WEST SUSSEX COUNTY COUNCIL CONSULTATION

TO:	Arun District Council FAO: Michael Eastham
FROM:	Stephen Gee WSCC - Highways Authority
DATE:	16 February 2021
LOCATION:	Felpham Site 6 Westmorlands Drive Felpham
SUBJECT:	FP/12/21/PL Minor alterations, following FP/239/19/PL, to the emergency access to include replace small section of 1.2m close board fence with 1.2m post & rail fence, addition of guard railings adjacent to northern gate, gate colour to be amended from grey to yellow & addition of 4 No. car parking spaces, to total 32 No. parking spaces, to serve the Community Centre building in lieu of the spaces in the layby.
DATE OF SITE VISIT:	n/a
RECOMMENDATION:	Advice
S106 CONTRIBUTION TOTAL:	n/a

| Site Name: Felpham                                                                                            | Car Parking Area FCP001 |                | <br><b>DAVID WILSON HOMES</b><br>WHERE QUALITY LIVES |

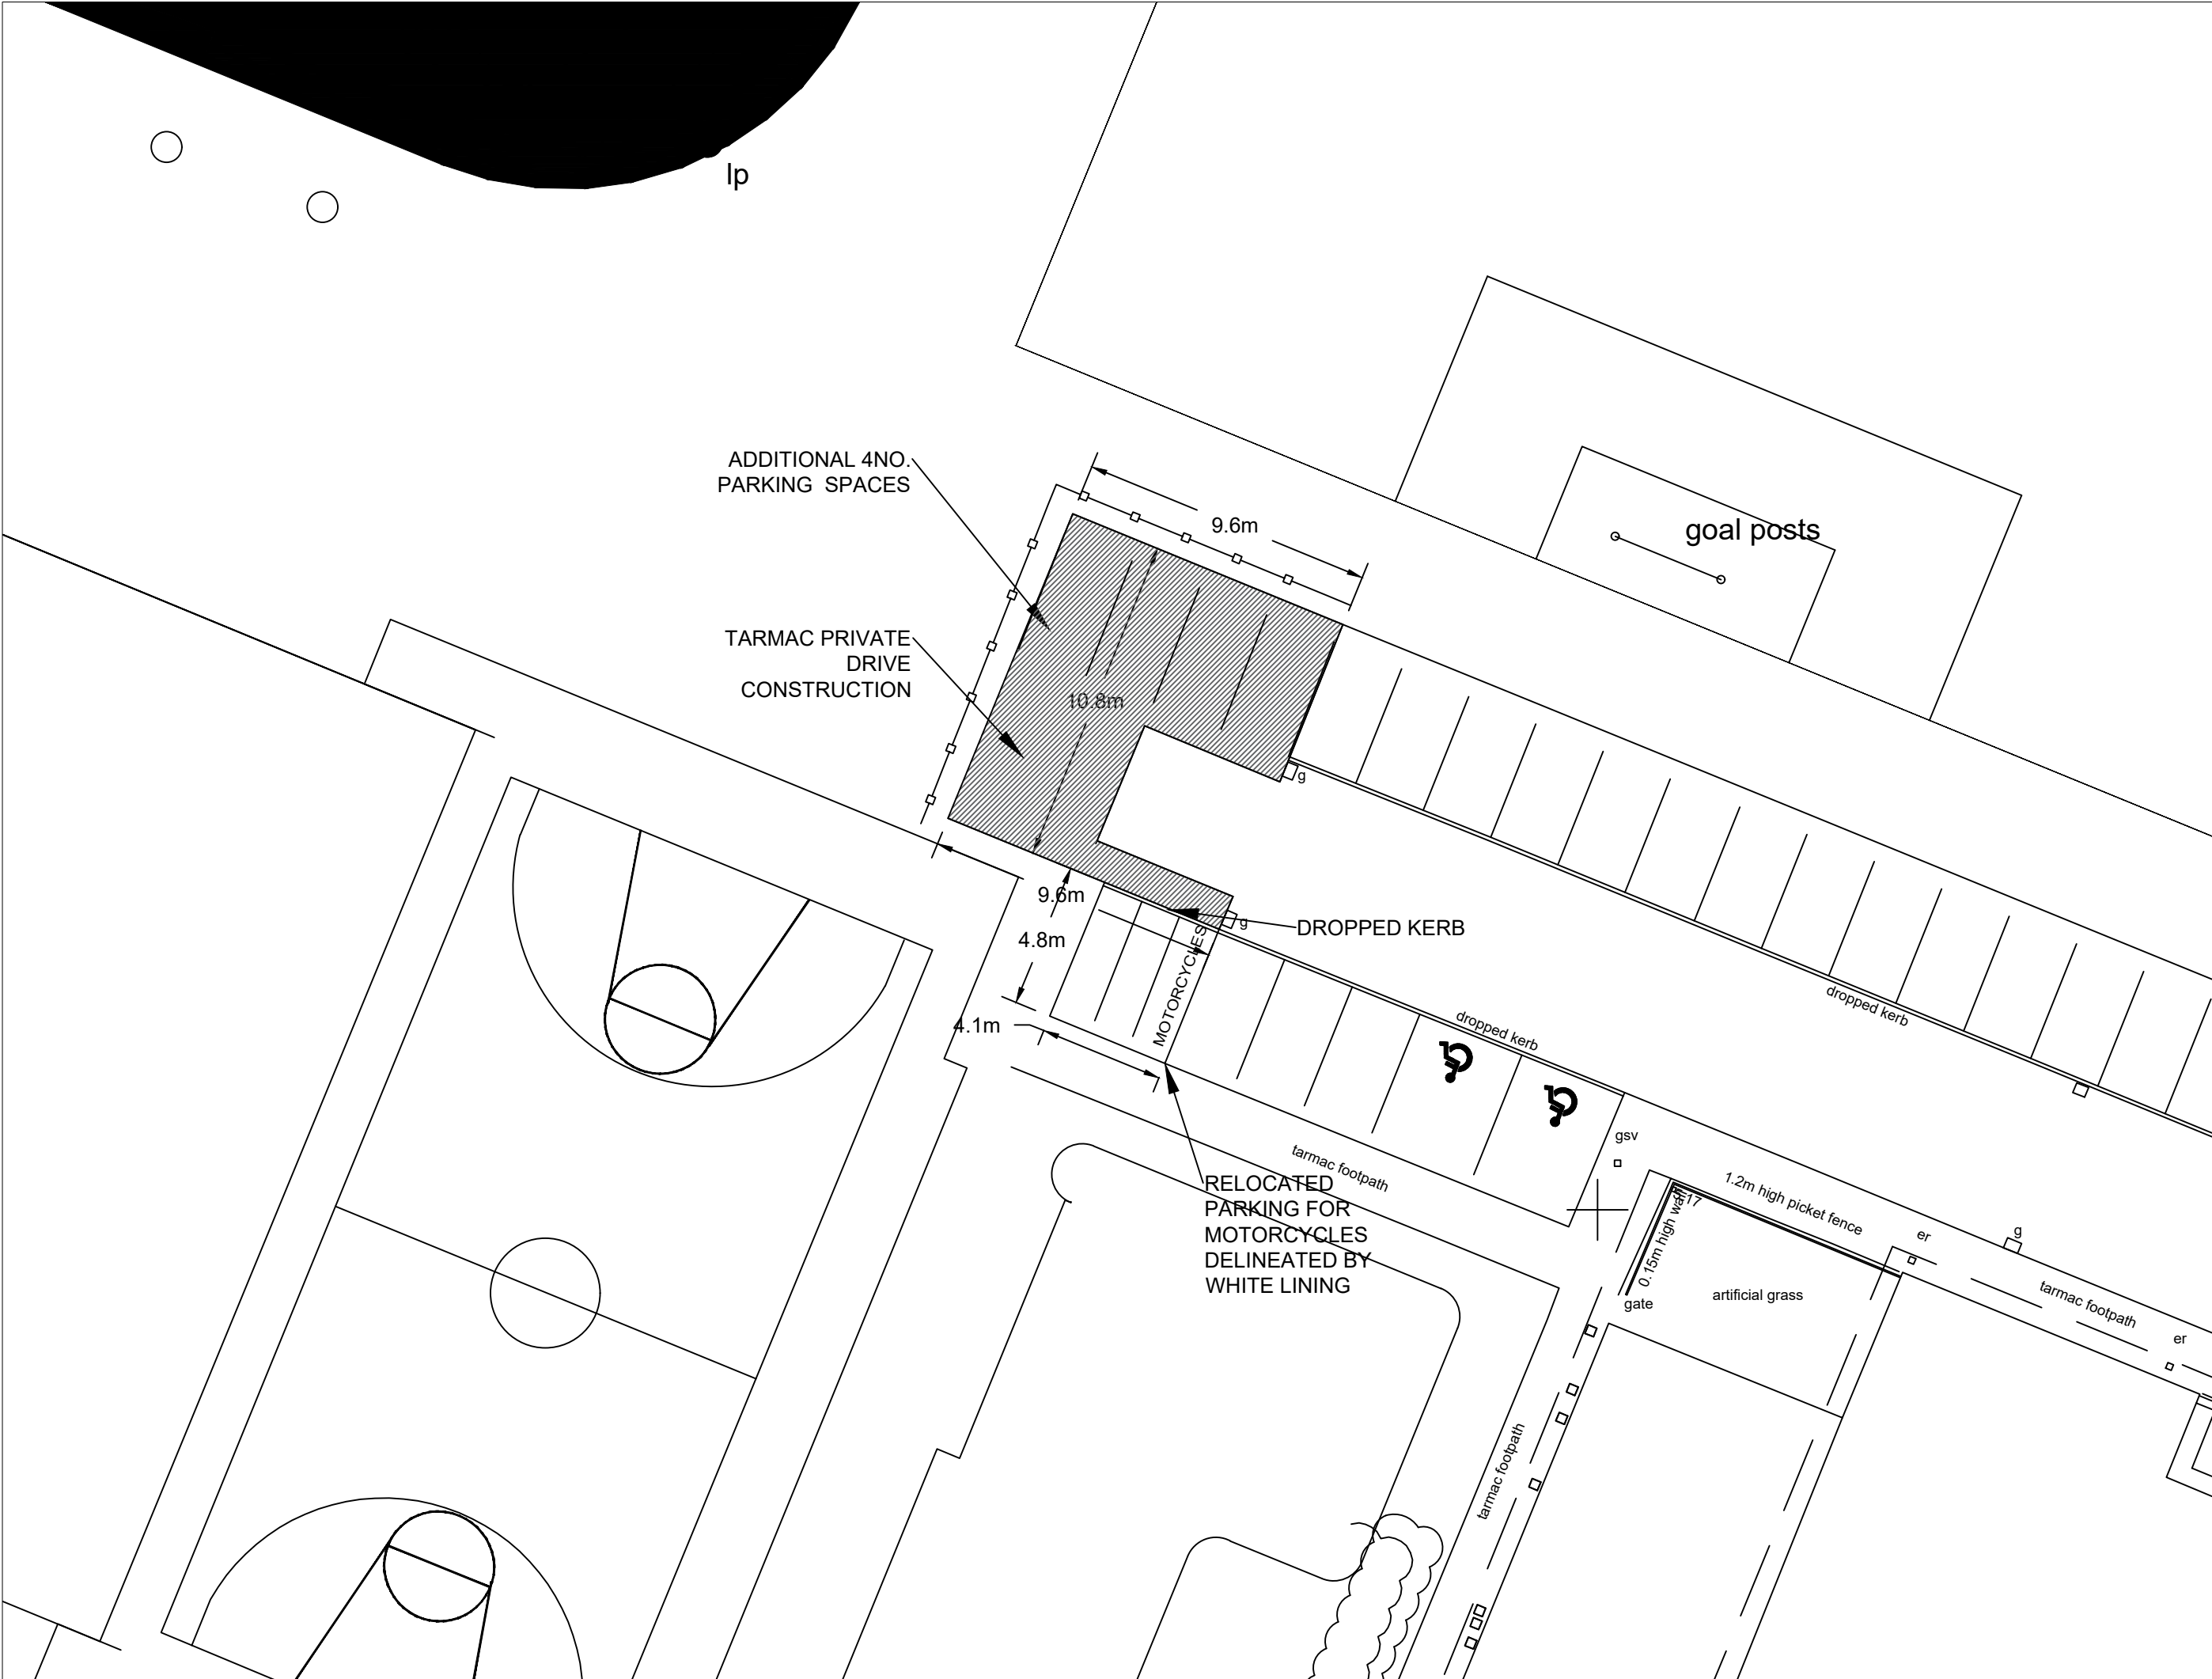
No objection would be raised to the amended parking spaces to serve the community centre
